Planning Consultation Request

Consultation Response from KC, Conservation & Design
2025/91184 land off, Bretton Street, Savile Town, Dewsbury, WF12 9BZ
Erection of two storey industrial unit (Use Class E(g)(iii)), with associated car park, service area and other associated works
Date Responded: 17/12/25 & 15/7/26
Responding Officer: SC
Responding Ref:

Update 15/7/26

bretton street elevation

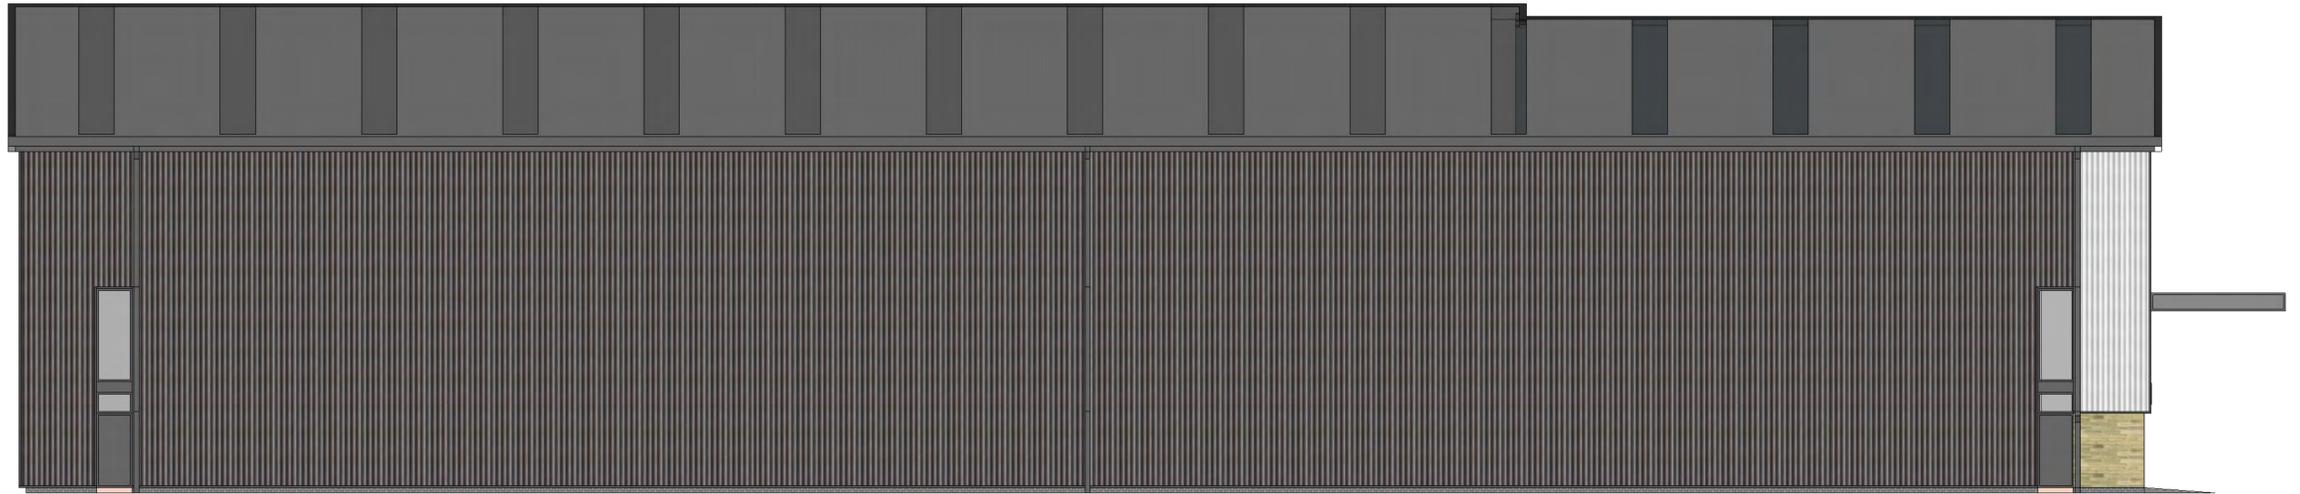
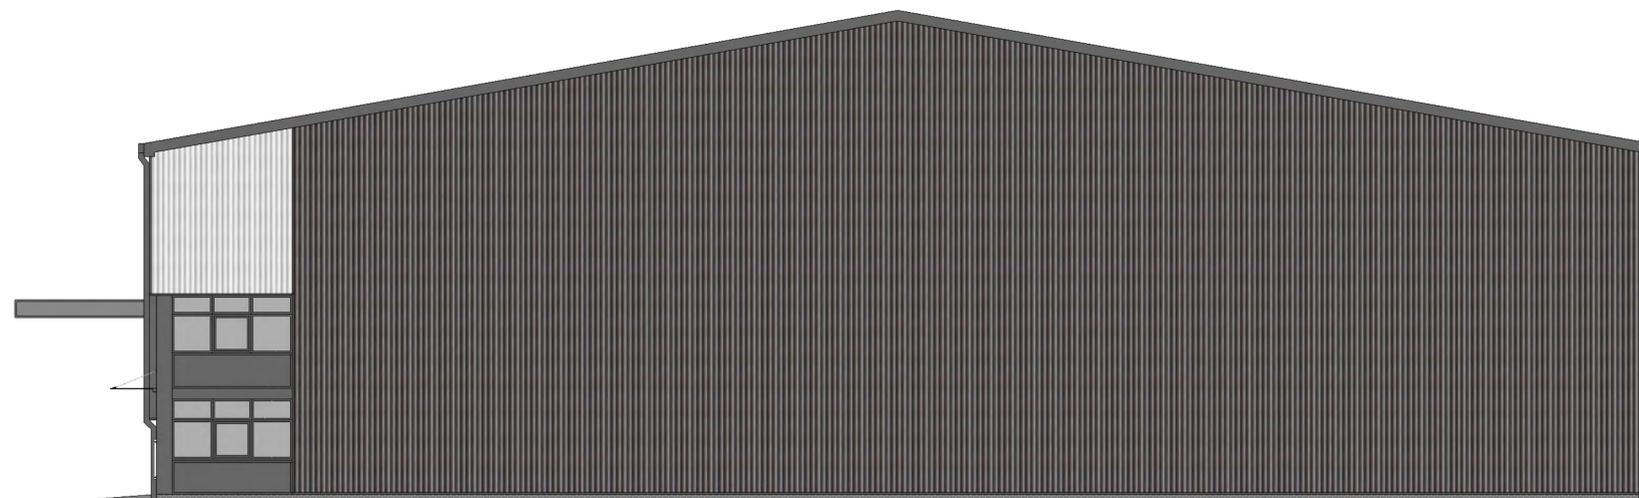
Materials for the structure could include some local natural stone in the base plinth, and use dark colours for sides and roof, with vertical cladding.
